CITY OF PORTLAND

Job ID: 2011-10-2354-ALTR

has permission to Second Floor Addition (Single Family Residence).

Conditions of Approval:

← 33' →
ROOF PLAN WITH SECOND STORY EXTENSION
WEST ↓ 1" = 5' DE 12/1/11

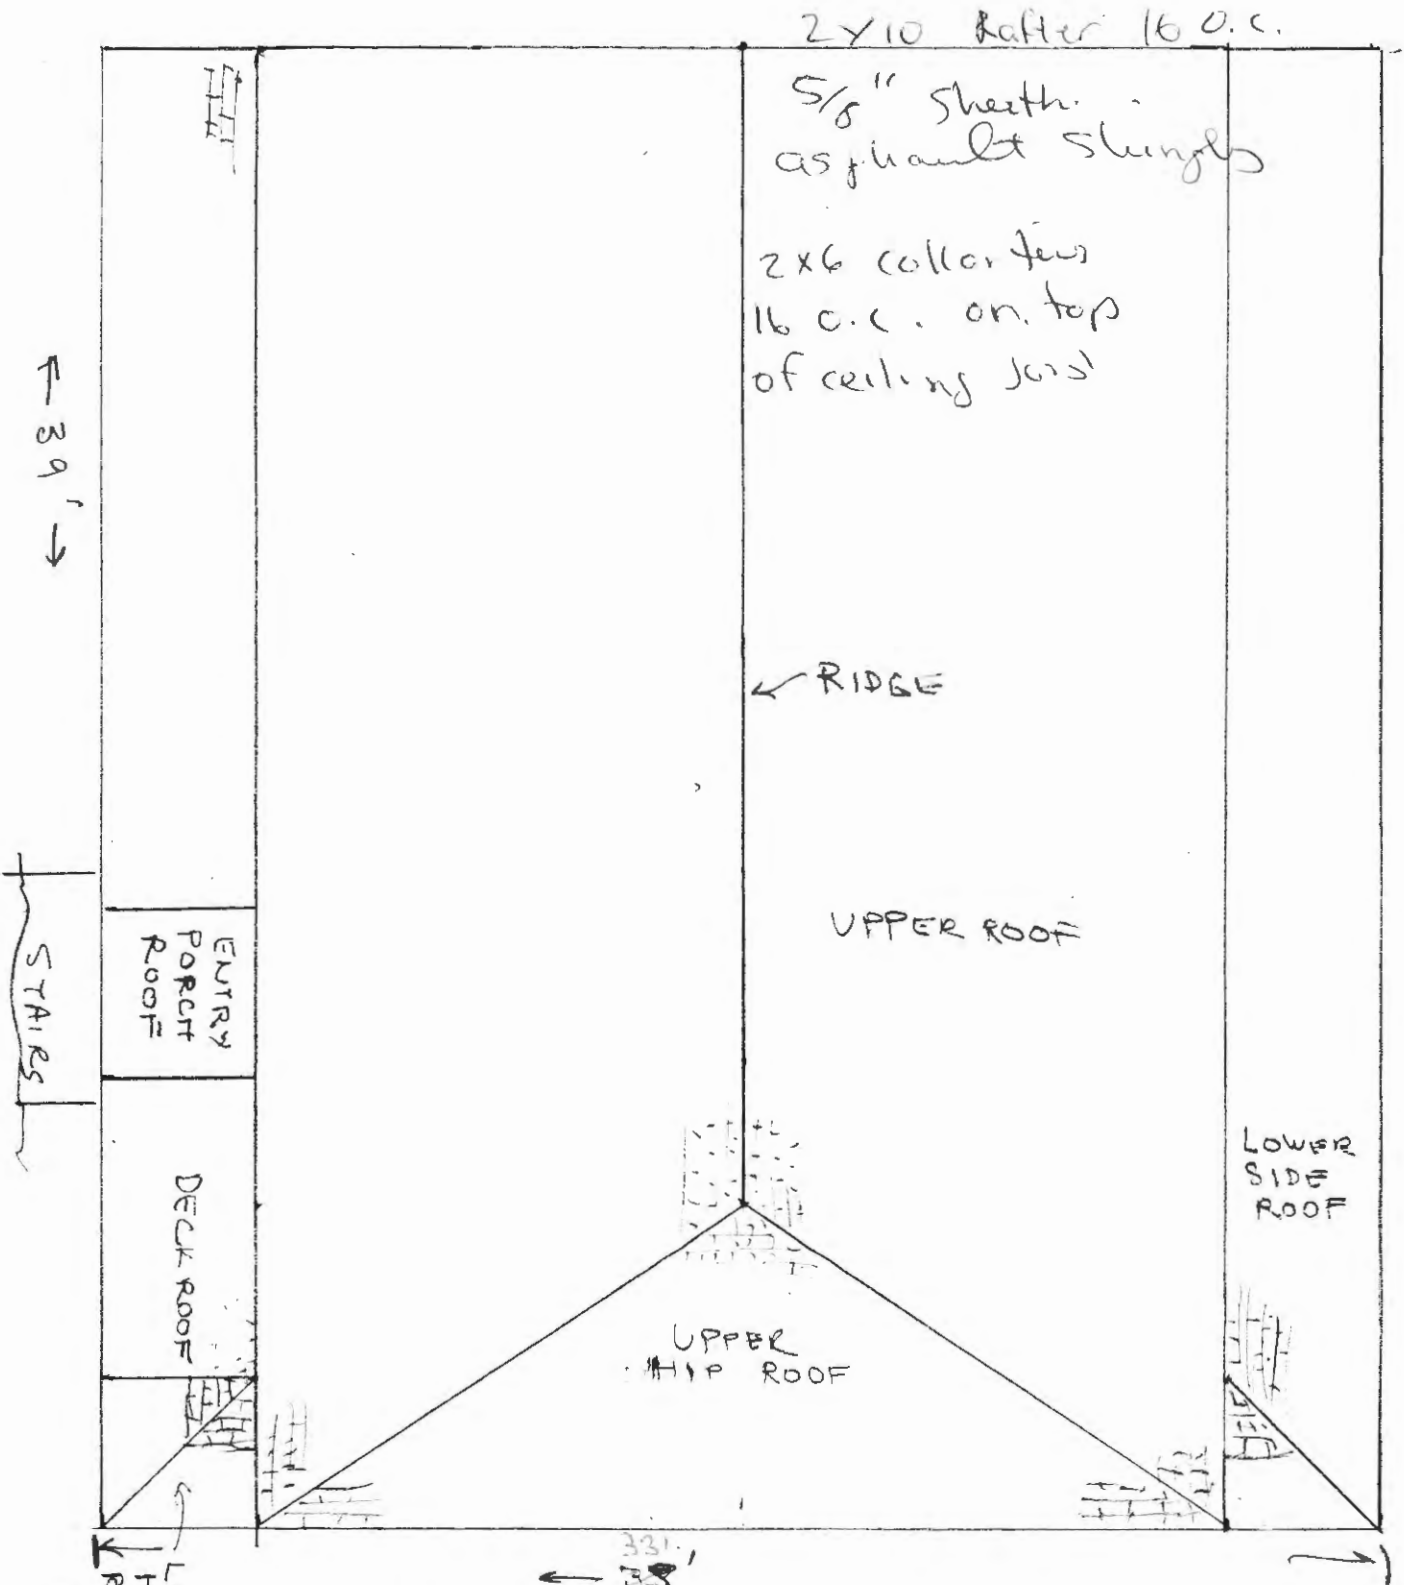
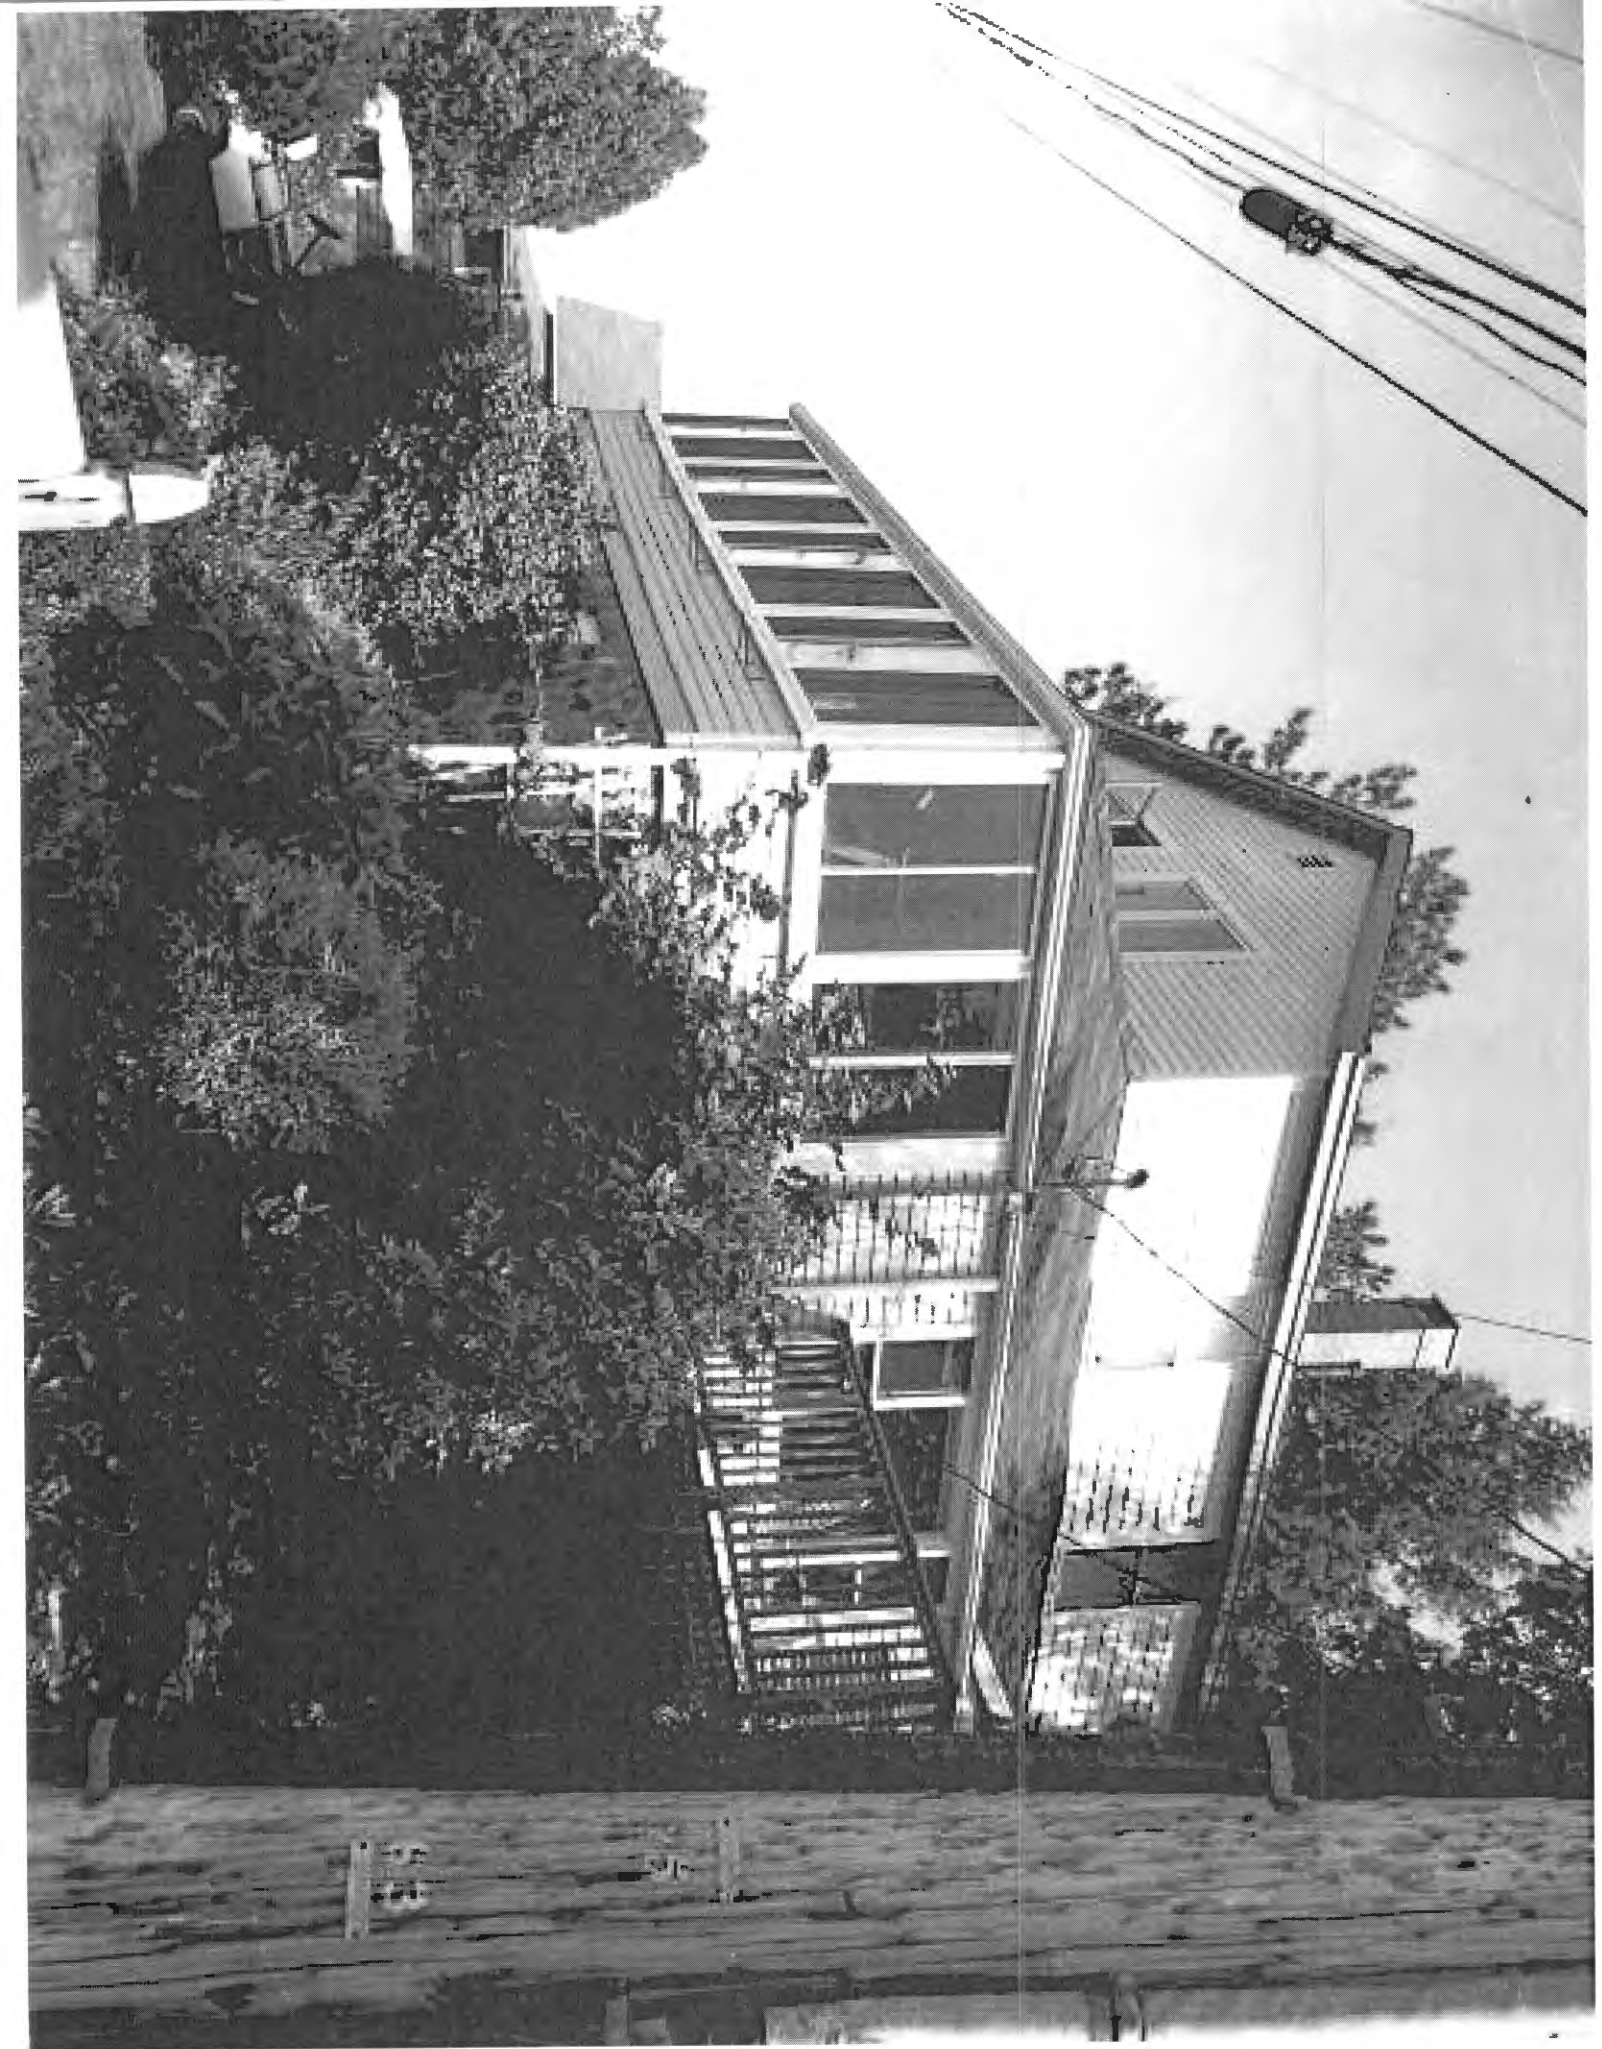
2. Roof Rafter framing and Connection shall comply with Section R802.3 & R802.3.1 of MUBEC.
3. A code compliant emergency escape shall be provided in the bedroom. Window sills in locations more than 72 inches from finished grade shall be a minimum of 24 inches (no higher than 44 inches) above the finished floor of the room, or in compliance with Section R612.4.2 Operation for emergency escape.

The existing roof adjacent to the new Master Bedroom has been strengthened with the installation of a new ridge board (2" x 10") and a double row of collar ties –top ties 2" x 4" and lower ties 2" x 8". I request that you add one additional rafter to support the end of the new ridge board which then will be supported by four (4) rafters.

The hip roof is constructed with jack-rafters, hip members and connections which follow conventional construction techniques at 16" oc. The jack-rafters are 2" x 10", the valley rafters are double 2" x 10" and the ceiling joists are 2" x 8". The strength of the rafter connections needs to be a minimum of 316 lbs uplift while the nailing done is 10-16d nails providing an up lift resistance of 600 lbs

This framing meets the intent of the IRC 2009 Code and will withstand any loads superimposed on it that are required by the afore mentioned code
